Application for a non-material amendment following a grant of planning permission.

Number	120
Suffix	
Property name	
Address line 1	Laund Road
Address line 2	Salendine Nook
Address line 3	
Town/city	Huddersfield
Postcode	HD3 3TY

Demolition of Existing Dwelling and erection of 7 No. Dwellings	
Reference number:	2019/90486
Date of decision	12/06/2020

Raise Plot 2 by 350mm

GROUND FLOOR PLAN

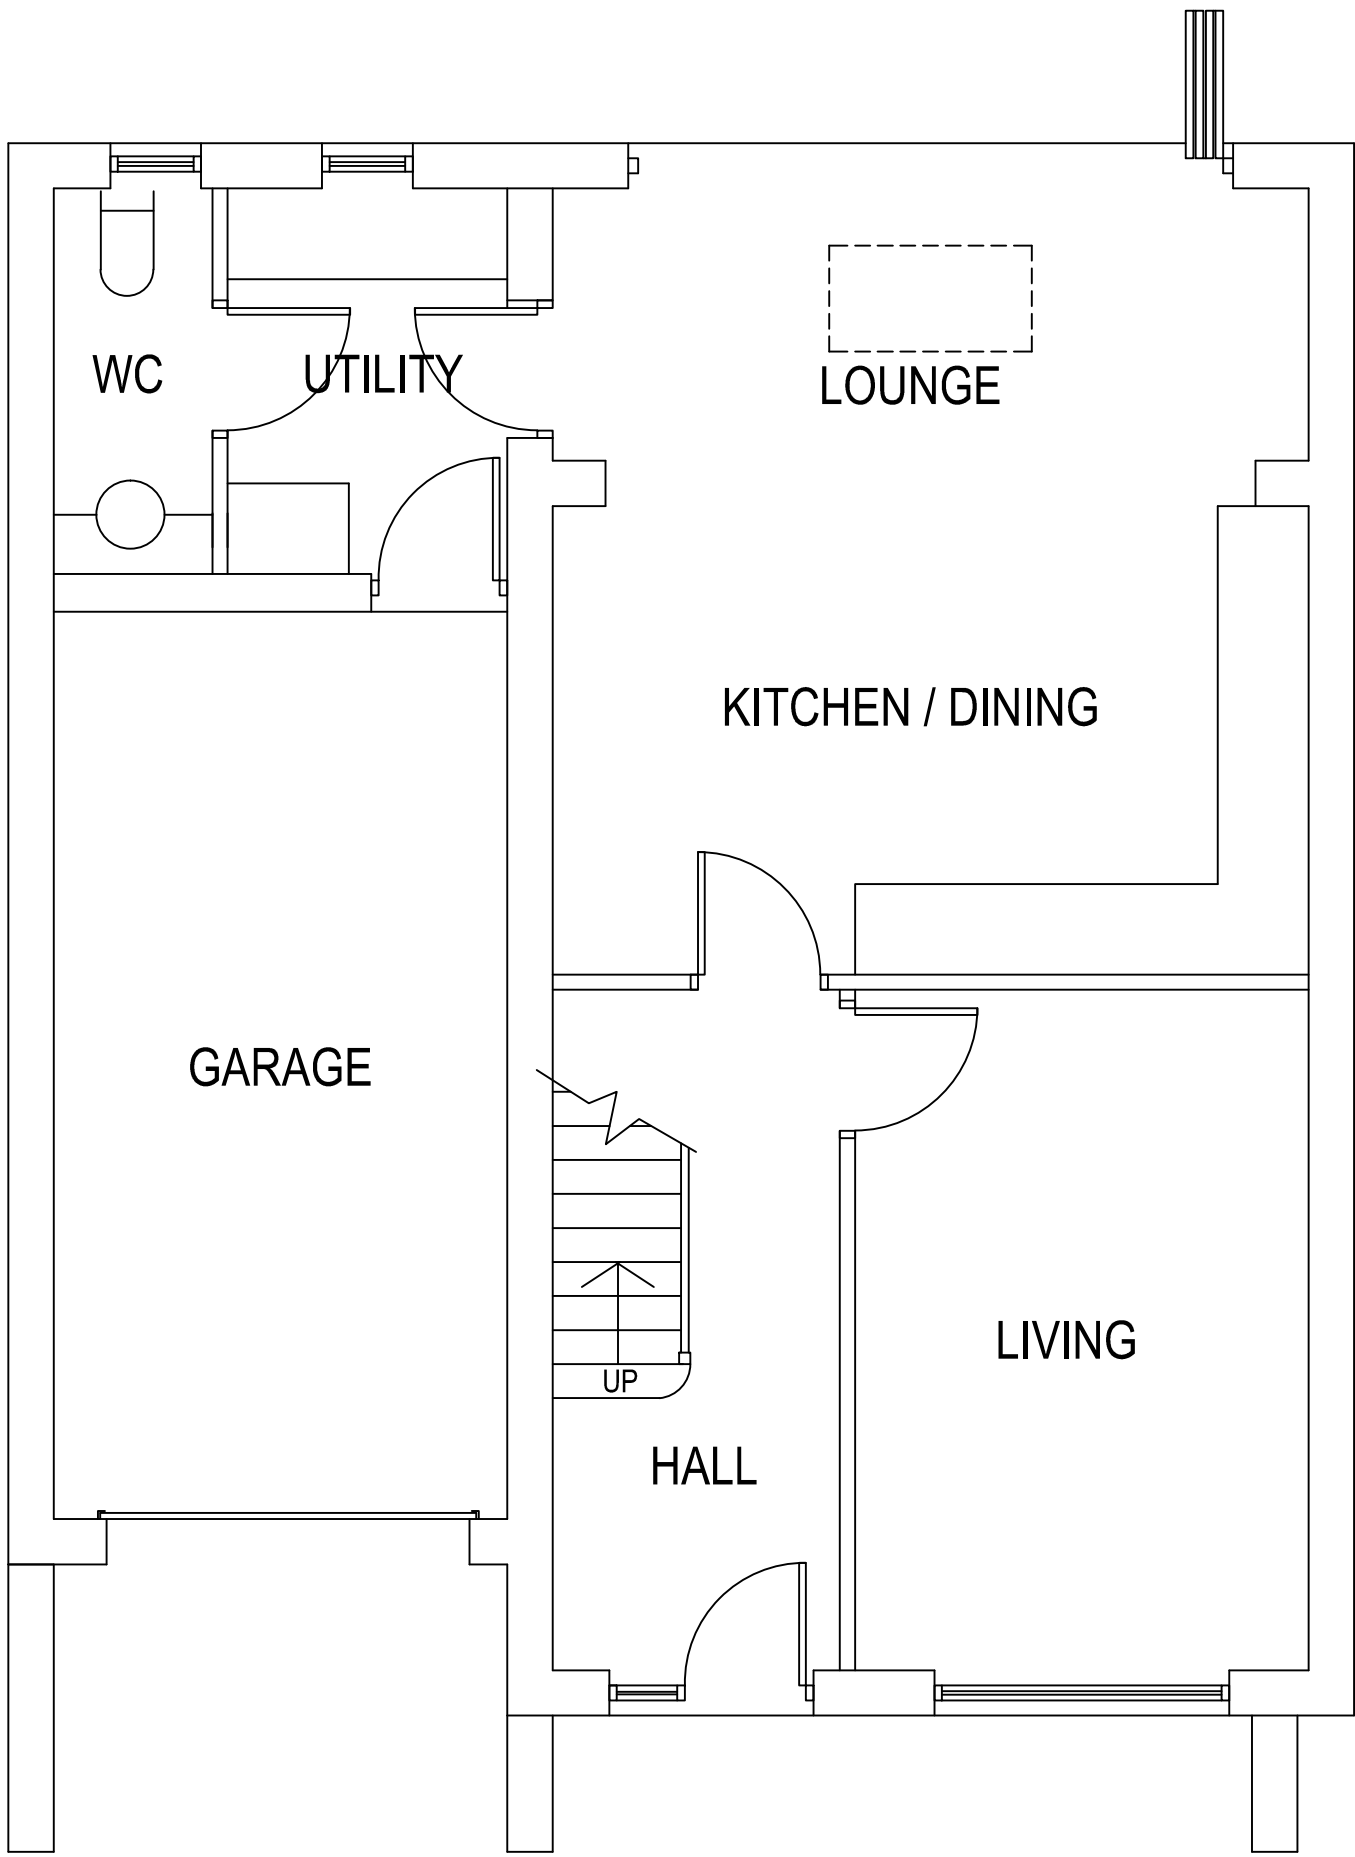
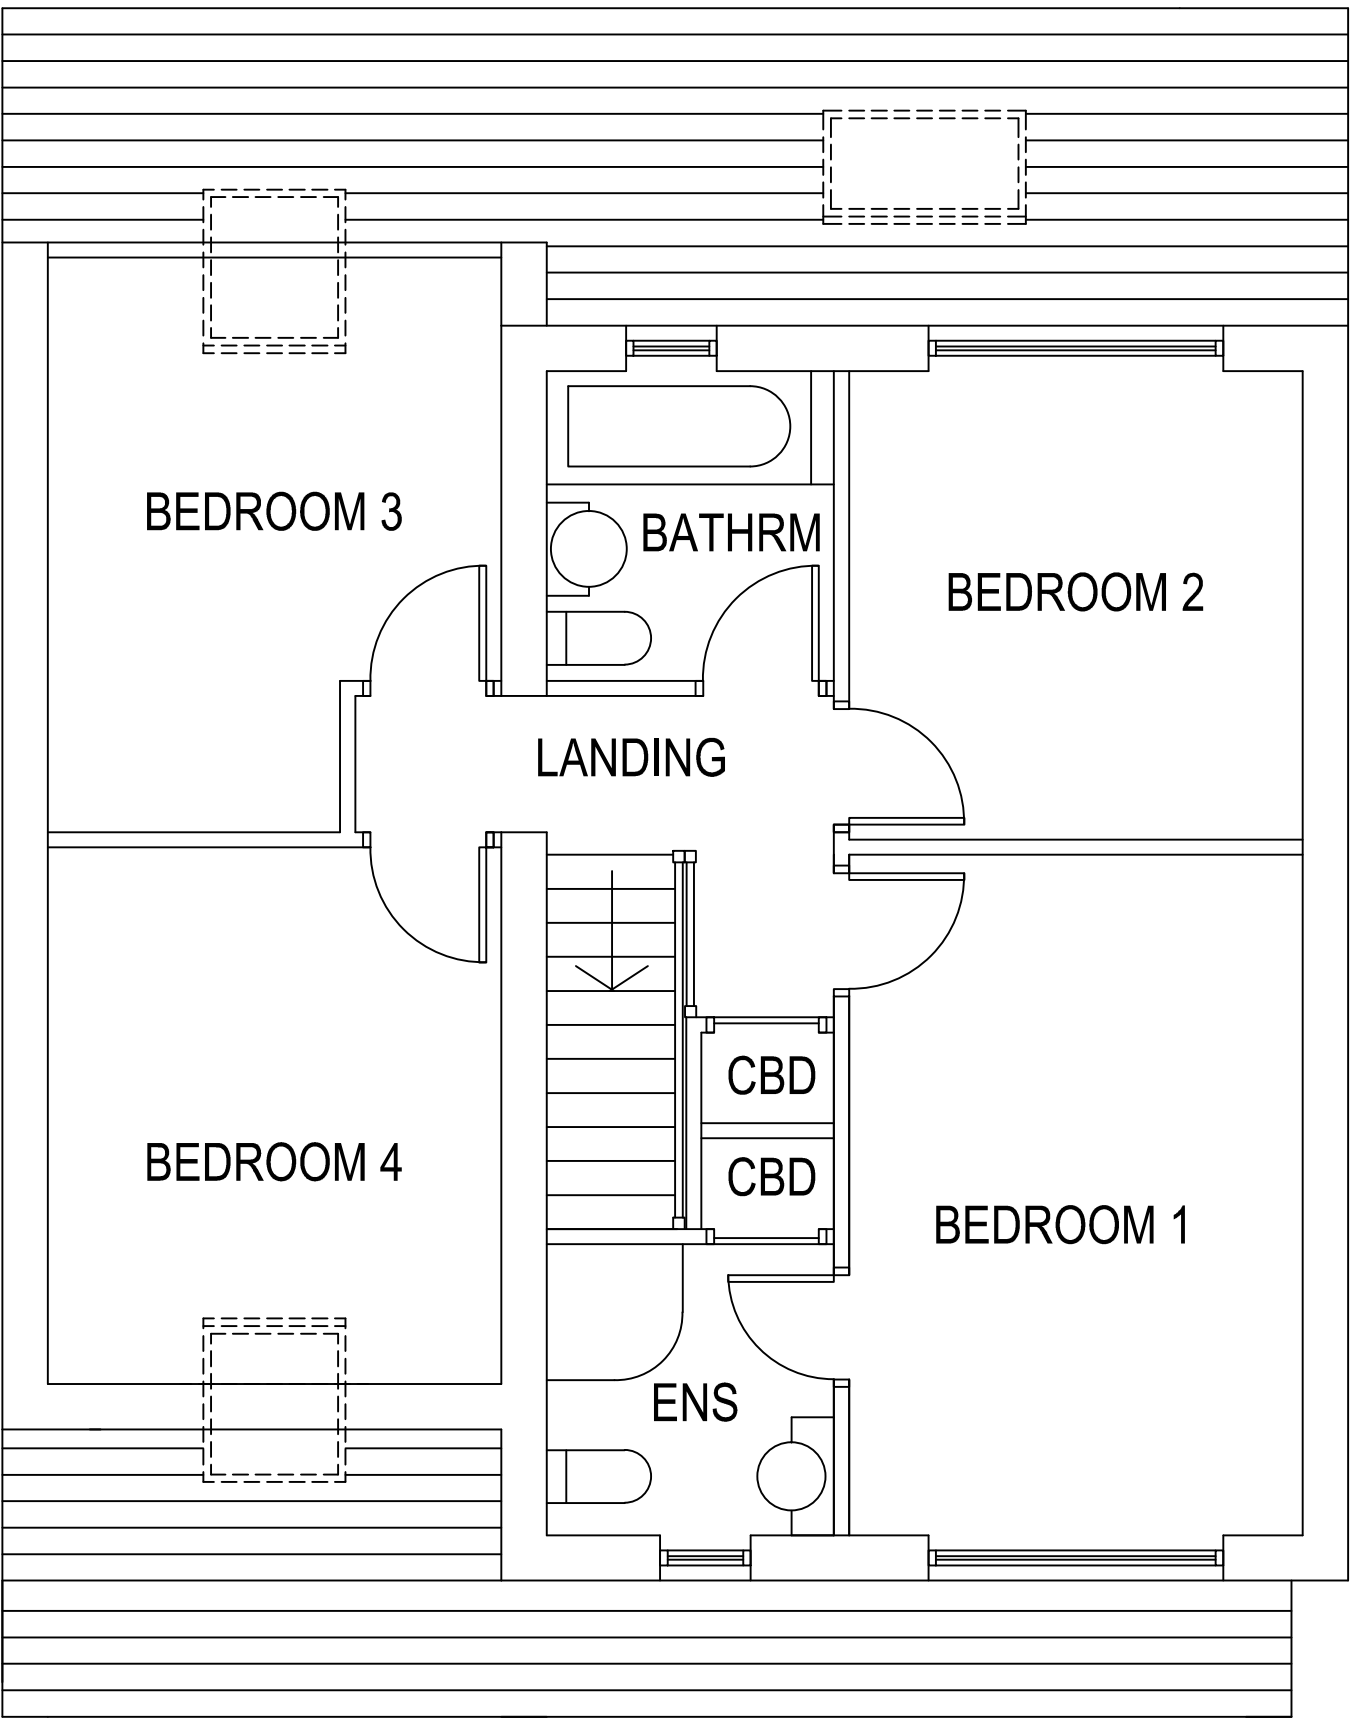
Due to the floor construction changing, from solid to suspended beam and block, due to incorporation of gas membrane
